**KIRKLEES METROPOLITAN COUNCIL
INVESTMENT & REGENERATION SERVICE**

**DELEGATED DECISION TO DETERMINE APPLICATIONS FOR
CONSENT, AGREEMENT OR APPROVAL REQUIRED BY CONDITION**

Reference No:	2025/44/91268/W
Site Address:	Land at, Penistone Road, Fenay Bridge, Huddersfield, HD8 0AW
Description:	Discharge of details reserved by conditions 17 (Retaining walls adjacent to highways), 25 (Boundary Treatments), 30 (Retaining Wall Materials) on permission 2022/93154 for erection of 68 dwellings with associated access, parking, open space, landscaping and infrastructure works (including installation of surface water attenuation tank)
Recommending Officer:	Katie Chew

Officer Report

PROJECT:	Standard Details
DRAWING TITLE:	Natural Stone retaining wall & railings

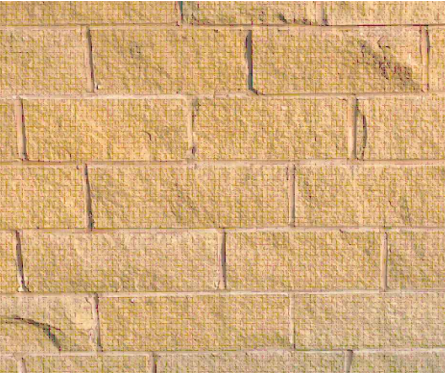
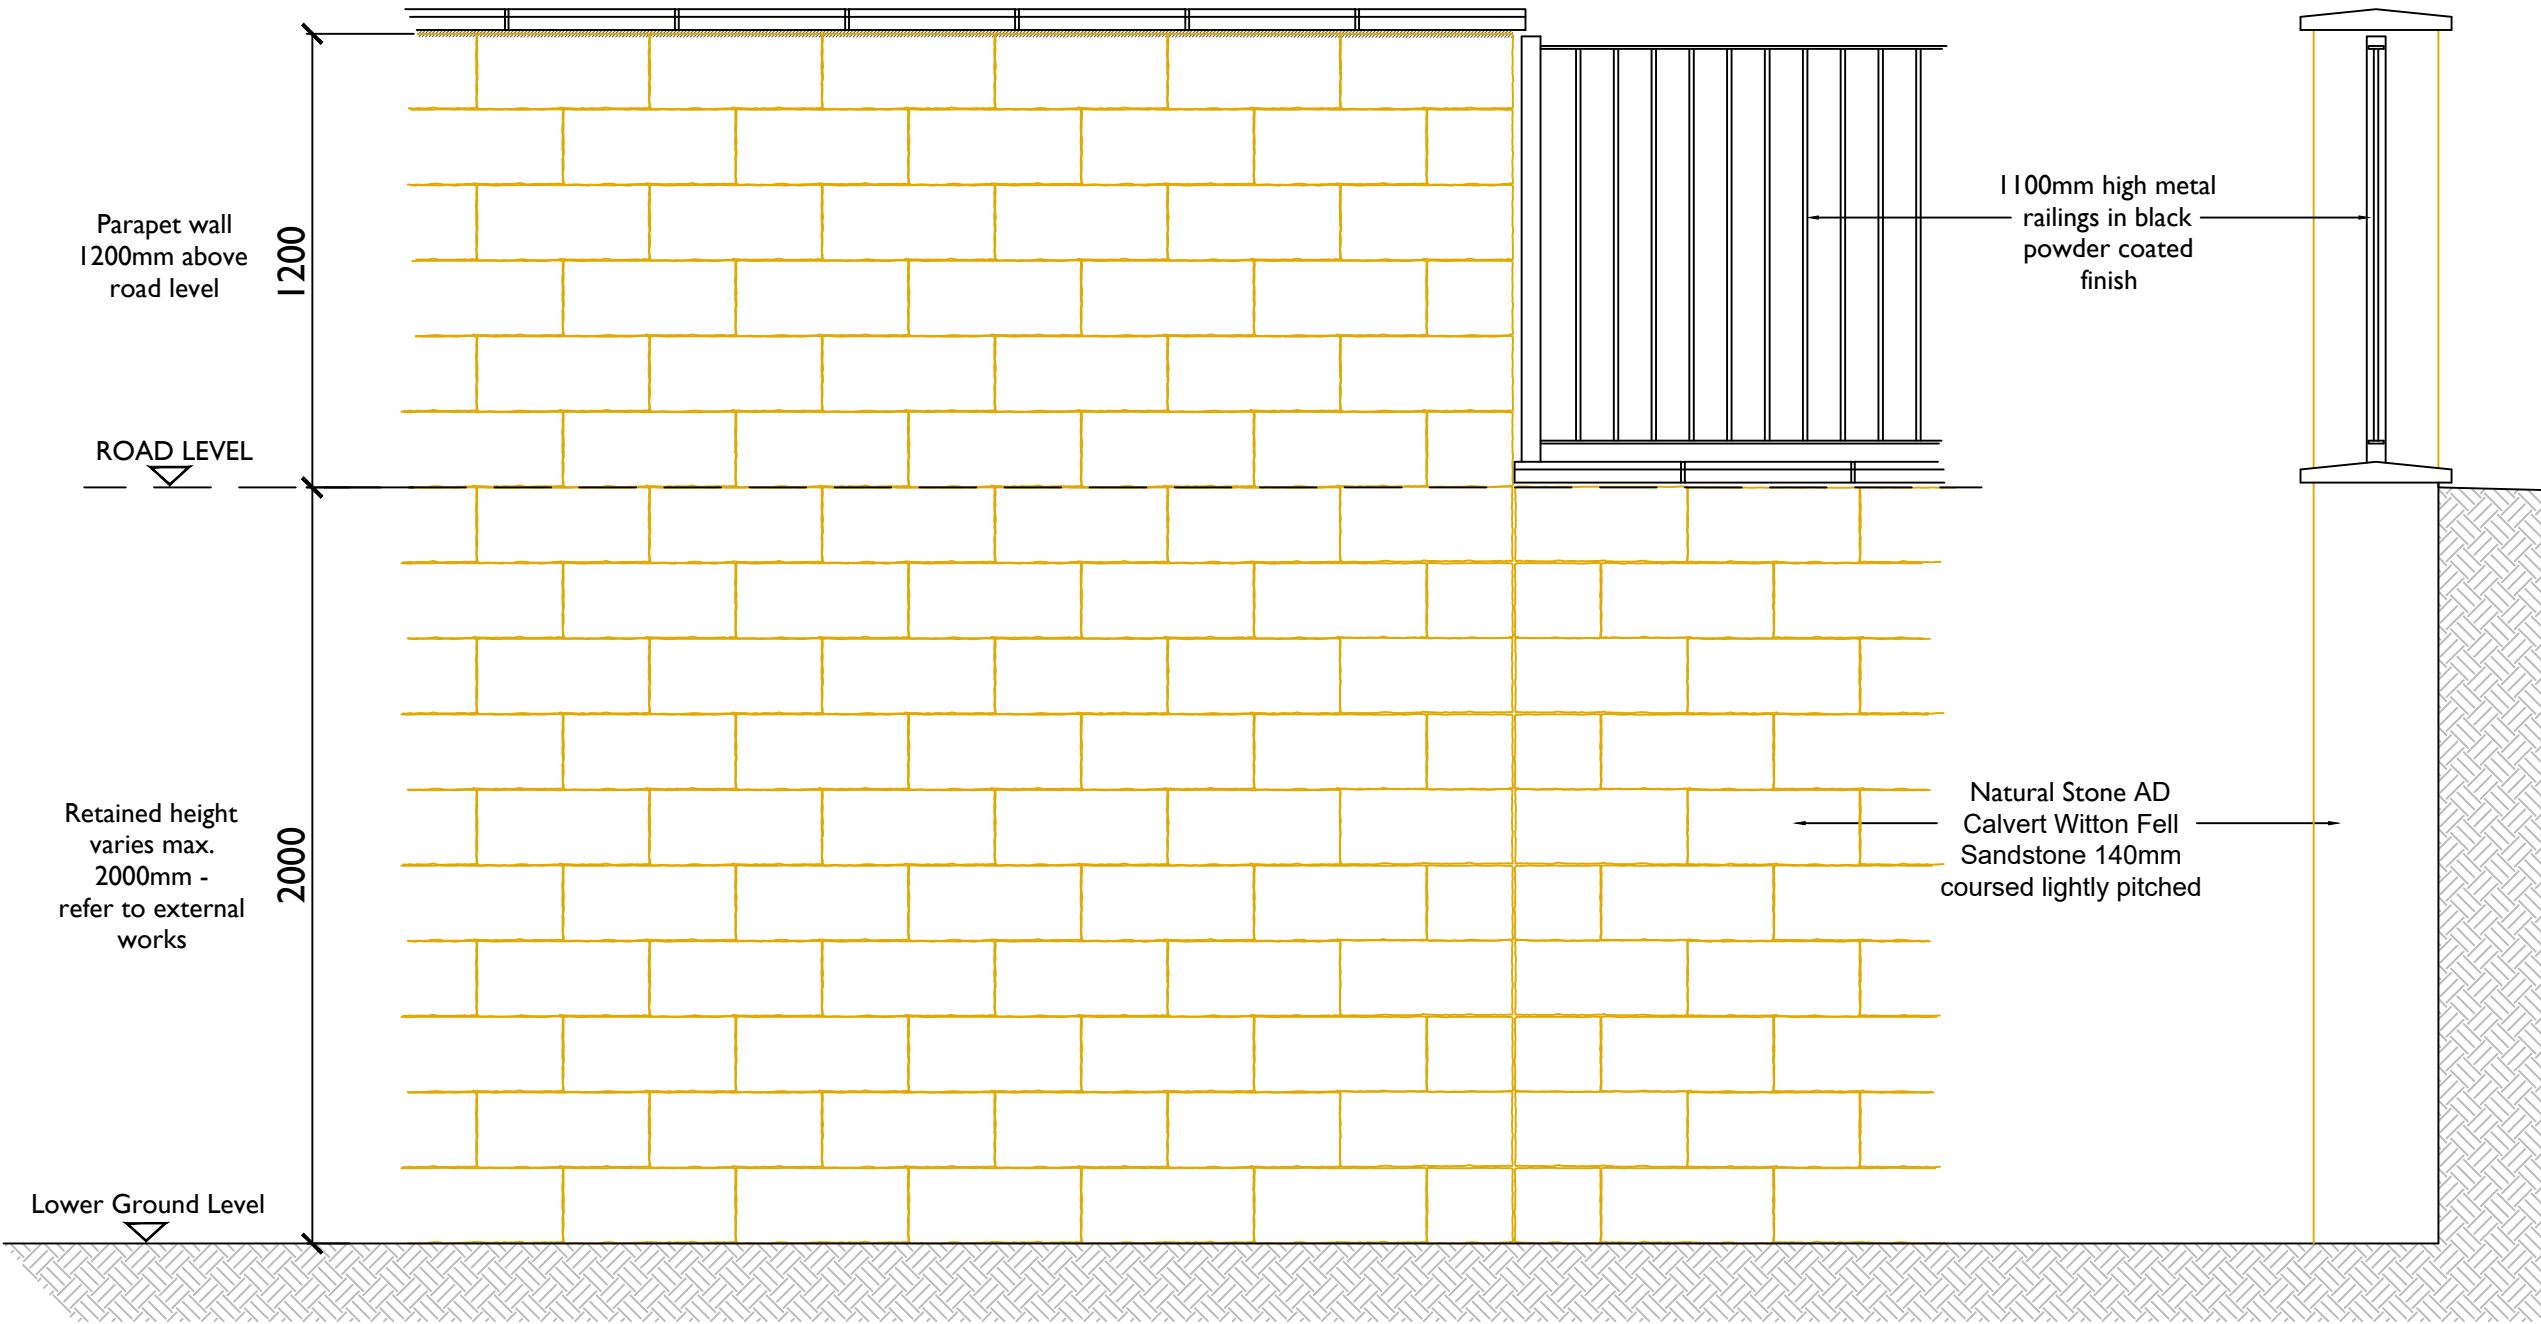
The boundary treatment plan also references a natural stone wall, 2m natural stone wall and natural stone wall with railings, shown within drawings NH/SD/PL/106 & NH/SD/S120/A/02 Rev B. These boundary treatments are to run along the western boundary of the site, adjacent to Penistone Road. The natural stone is to be sourced from AD Calvert's Witton Fell and is to comprise of sandstone 140mm coursed lightly pitched. This is the same as the natural stone secured on plots facing Penistone Road and approved via the discharge of condition application 2024/92428 (condition 28). The quarry is located to the west of Ellingstring and is helpfully identified within the 'Source for Natural Stone for boundary/retaining walls' document, received 08/05/2025. Railings are to comprise of 1.1m high metal railings in a black powder coated finish. Given the above, Officers consider these materials and their locations to be acceptable.

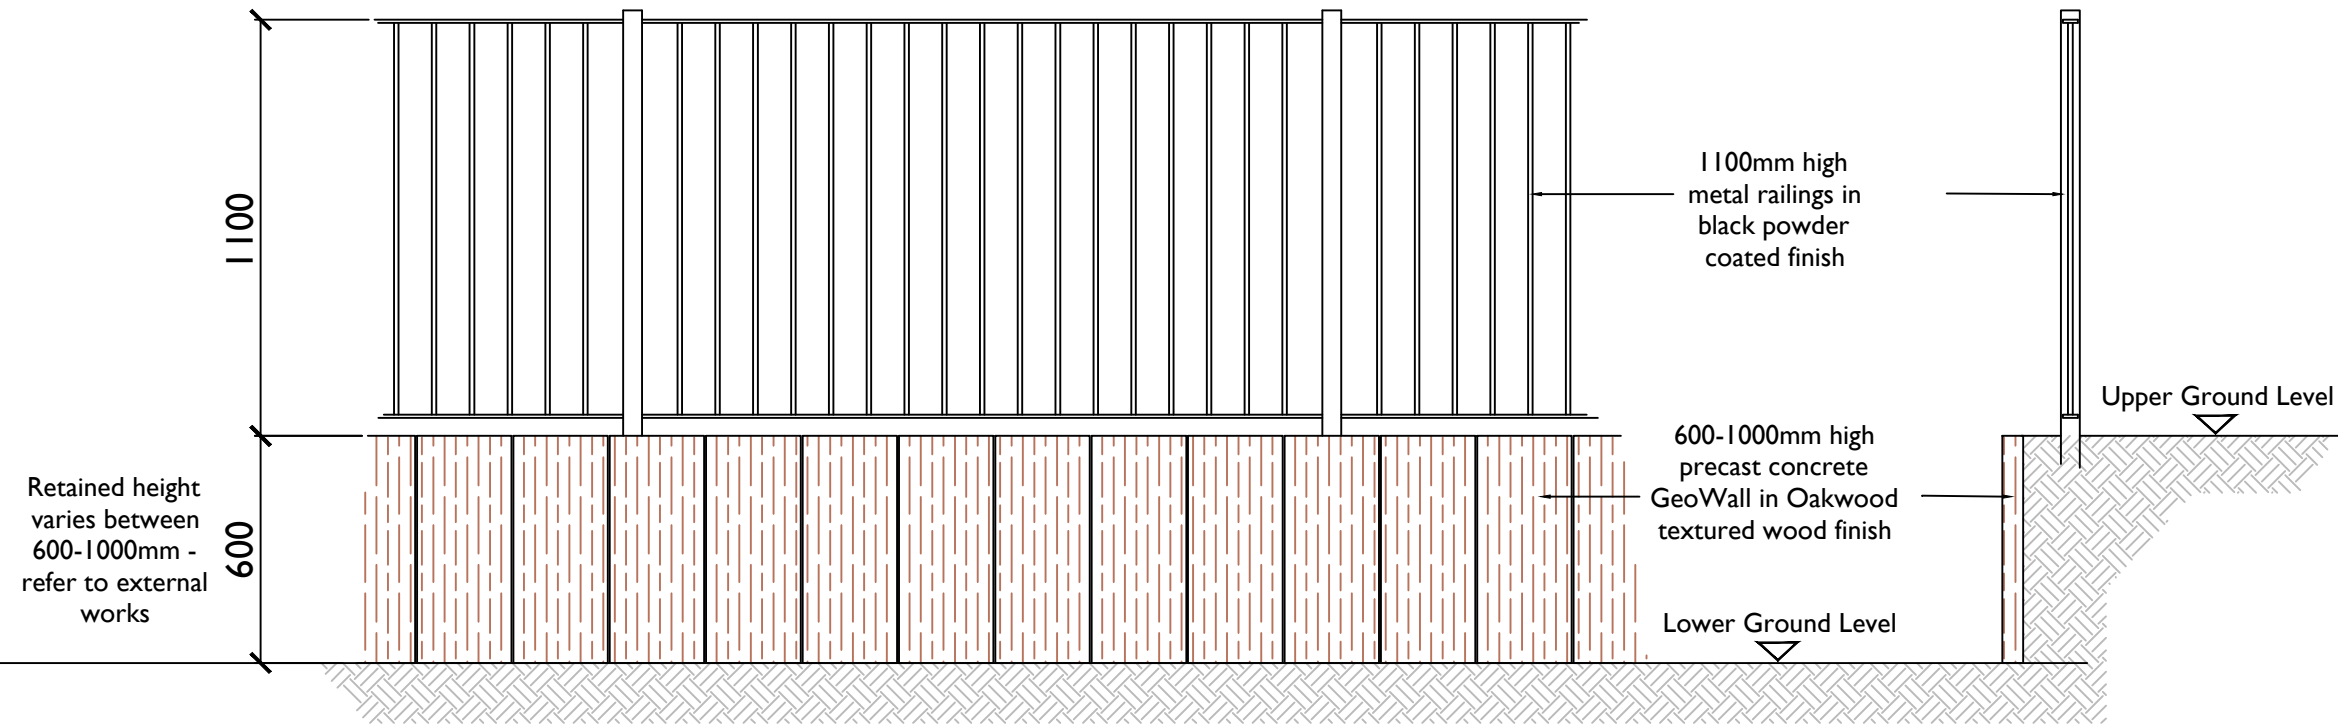
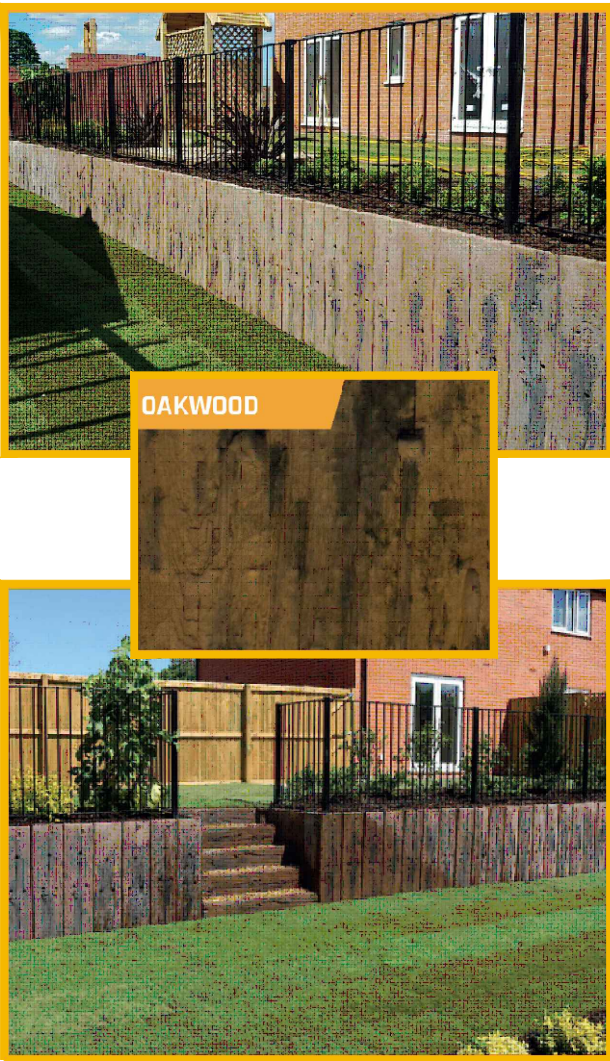
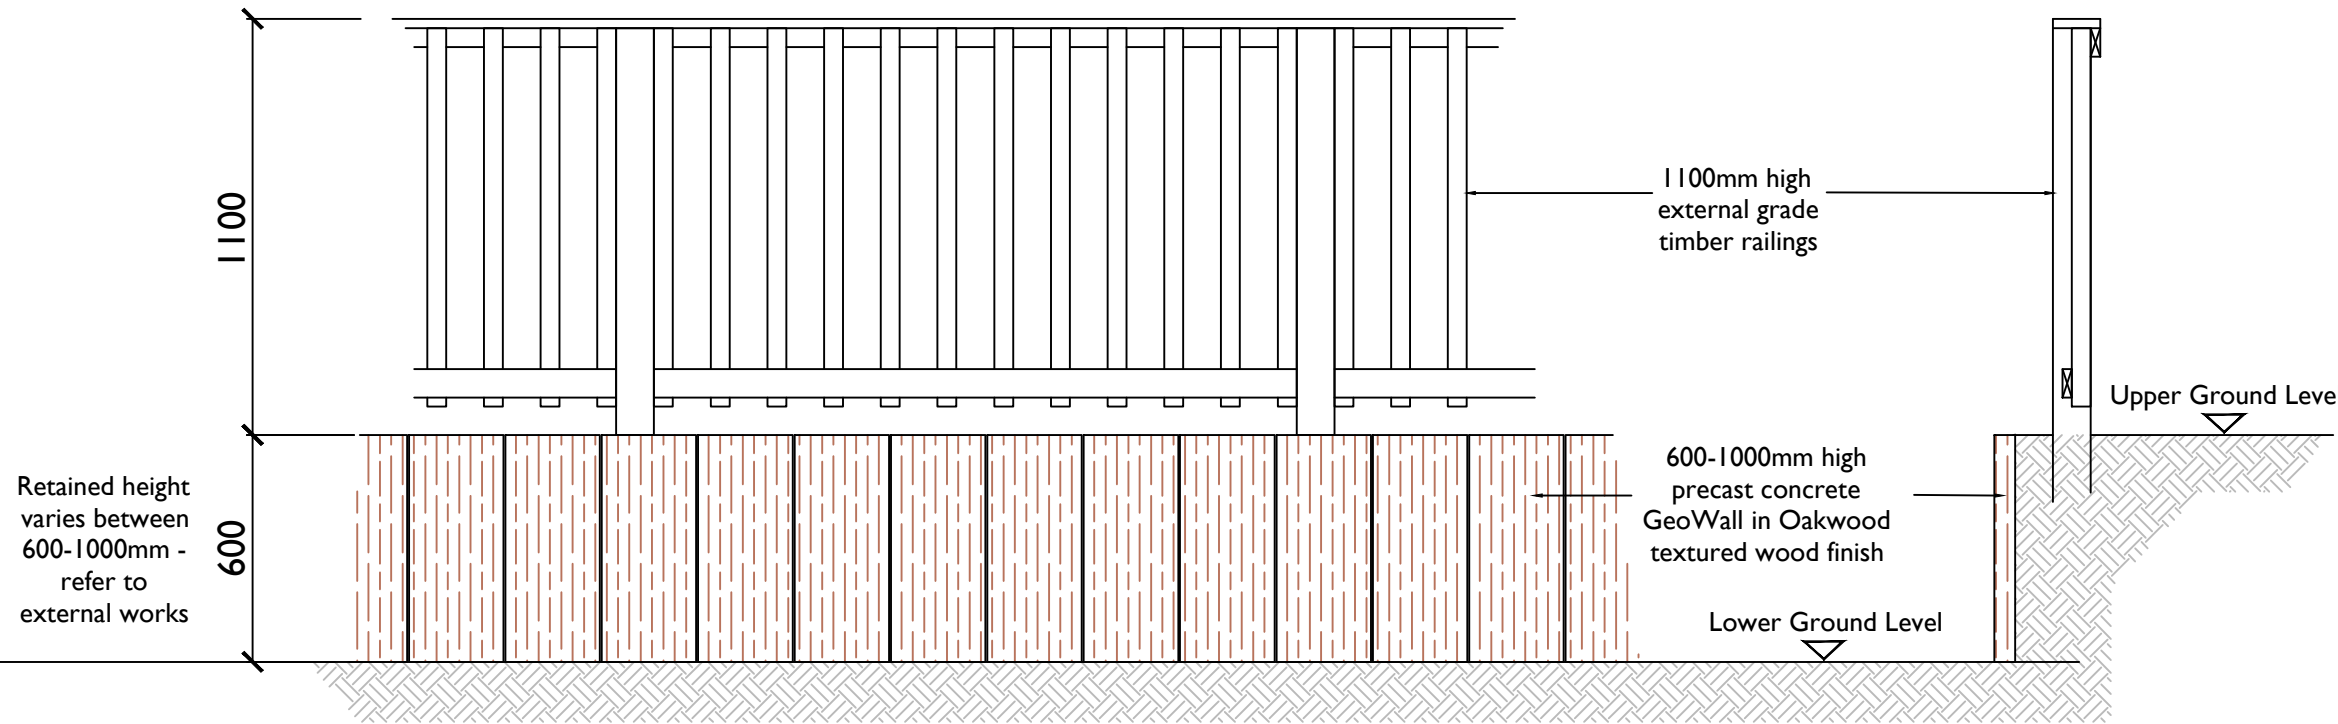
Finally, to the front of plots 5-16 a GeoWall and 1.1m metal railings are now proposed. This does differ to the original consent however, the applicant's agent has confirmed that the retaining solution was altered to sheet piling (to the rear) as a result of further site investigation into the existing ground conditions. Plot levels were then raised in order to minimise the impact on the

rear gardens and to create a larger level/gently sloping amenity/play space. With the raising of the floor levels, retaining walls were introduced on the front aspect along with fall protection (railings). The road levels remain unchanged due to drainage constraints. This element of the scheme is deemed to be acceptable.
